15 November 2013

STATE SIGNIFICANT DEVELOPMENT NO.5251 - DUBBO ZIRCONIA PROJECT (DZP), TOONGI, DUBBO LOCAL GOVERNMENT AREA

To this end, the following comments are provided in respect of the project and the Environmental Impact Statement (EIS) on behalf of Dubbo City Council.

Figure 11: Proposed Transport Routes

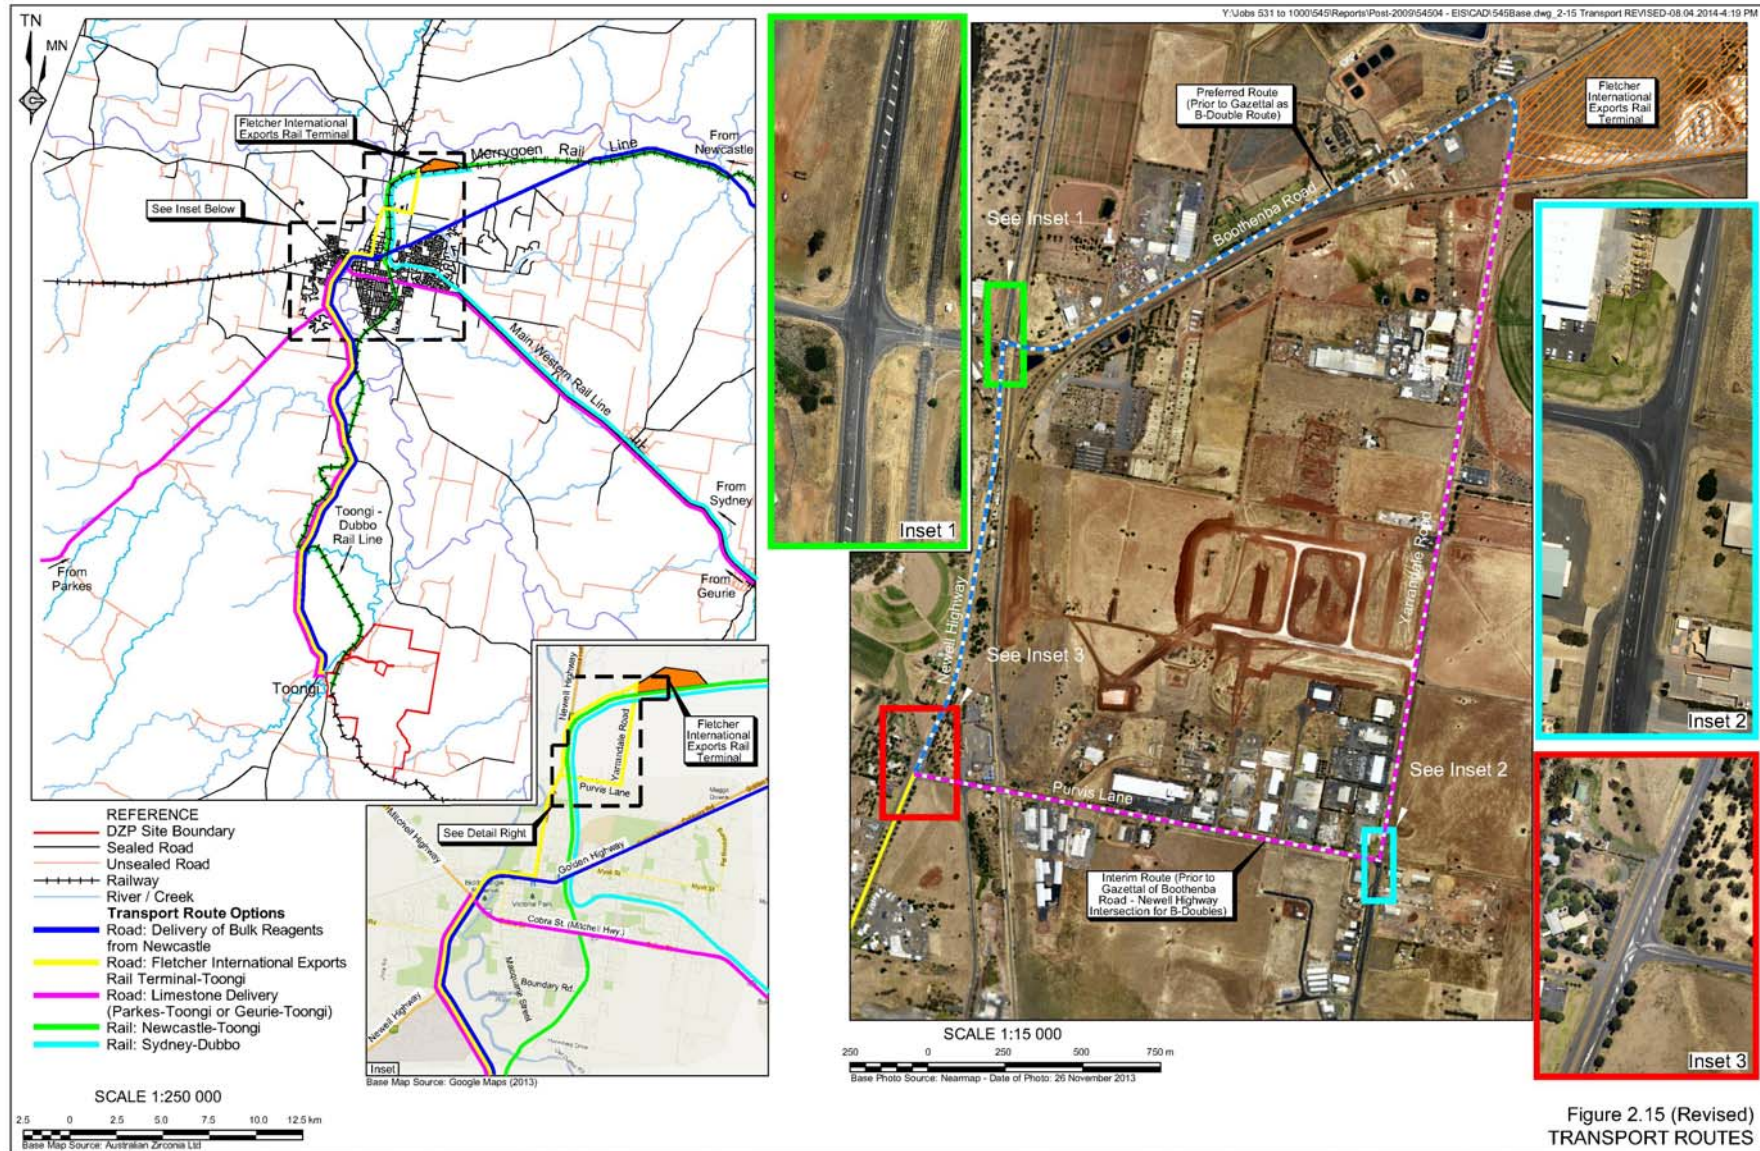
2. Unfortunately, various comments within the Environmental Impact Statement (EIS) do not give Council confidence that the Rail Line will be re-opened (and/or vigorously pursued by the proponent) which would then place all transport to be 'on-road' (in particular from Council's perspective onto the Obley Road - a Council-owned and maintained road).

In the absence of specific confirmation from the proponent regarding Option A – (Rail to Toongi), it is considered that likely condition(s) will need to be formulated around Obley Road being required to carry all of the transportation requirements for the DZP.

- (a) The EIS is unclear with regard to the total daily truck numbers (and truck movements) associated with Options B and C – Transportation to the site by road.

- (b) Option B – Rail (to Dubbo)/Road. It is distinctly likely that B-doubles will be utilised in transportation of reagents to the DZP Site. The issue (number/consequence) of B-doubles being utilised needs to be addressed further in the EIS.

- (c) Whilst it would appear on face-value that substantial work (by the consultants) has been undertaken on the required Obley Road upgrades (bridge upgrades, level crossings, curve realignments, road widening, pavement upgrades and intersection upgrades), it would appear that more 'fine detail' of these works will be required. This was acknowledged by the proponent at a community meeting on 23 October 2013.

- The pavement seal (Obley Road) would be increased to **10 metres** for the entire length of the road (except where **existing** bridge crossings prevent this).

Council's letter to the NSW Department of Planning and Infrastructure, dated 1 May 2012 (DG requirements), requested Obley Road to be reconstructed as a 10 metre seal, on a 12 metre formation. Within the EIS and Part 11, various suggestions are either an 8.5 metre seal or a 9 metre seal.

Council maintains its request for a 10 metre seal on a 12 metre formation. This width would enable 2 x 3.5 metre-wide sealed travel lanes (one in each direction); 1.5 metre-wide sealed road shoulder either side; plus a 1.0 metre-wide gravel shoulder on either side. Having regards to the aspect that Obley Road is extensively utilised by cyclists, is a school bus route and also acts as a scenic/tourist drive route (Molong-Cumnock-Yeoval-Dubbo), it is considered that a 10 metre seal (on a 12 metre formation) is required.
